Our Reference: P2930.005L

2 November 2017

RE: TWEED SAND QUARRY LOT 22, (DP1082435), LOT 23 (DP1077509) AND LOT 494 (DP720450) CRESCENT STREET CUDGEN RESPONSE TO RMS COMMENTS

Figure 2.1: Development Traffic Generation

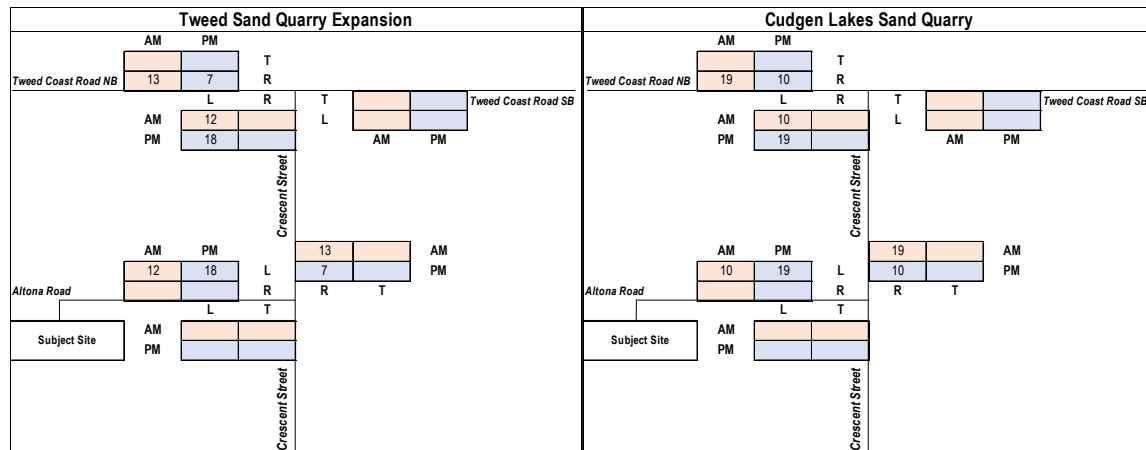
The identified haulage for the subject development is also the approved route for the Cudgen Lakes Sand Quarry under Project Approval MP05_0103. The supporting Traffic Impact Assessment (TIA) should address the cumulative traffic and road safety impacts of existing and proposed development in the subject area.

Based on the proposed development and Cudgen Lakes Sand Quarry traffic generation, Figure 2.1 and Figure 2.2 details the combined traffic volumes assigned to the surrounding road network during the AM and PM peak hours.

Figure 2.5: Tweed Coast Road / Crescent Street Intersection Layout

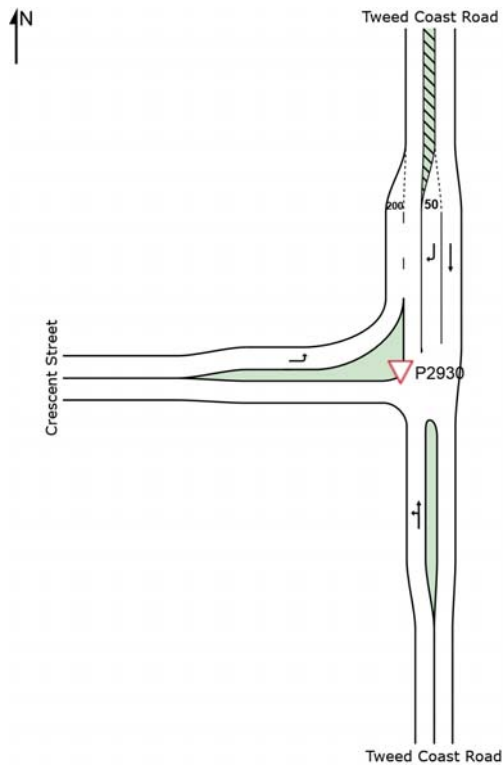
Project Approval MP05_0103 requires an upgrade of the Tweed Coast Road and Crescent Street intersection prior to the transportation of sand by road. Consideration should be given to identifying an equitable arrangement for delivery of any intersection improvements required to address the cumulative road safety and traffic impacts of approved developments in the subject area.

Figure 2.5 and Figure 2.6 show the Tweed Coast Road / Crescent Street and Crescent Street / Altona Road priority controlled intersections respectively.

As an intersection approaches Degree of Saturation (DOS) 0.85 or 85% it's capacity begins to have impacts on the surrounding road network. The above SIDRA results demonstrate that both priority controlled intersections perform acceptably (DOS < 0.85) and do not have any significant queuing impacts. Upgraded intersection layouts are therefore considered appropriate to accommodate the proposed development combined with Cudgen Lakes Sand Quarry. Detailed SIDRA Outputs are presented in Attachment 1.

As per the above, the Tweed Coast Road / Crescent Street and Crescent Street / Altona Road priority controlled intersections do not require intersections improvements above those already proposed due to the proposed Cudgen Lakes Sand Quarry development traffic when considering cumulative road and safety impacts with the Cudgen Lakes Sand Quarry development.
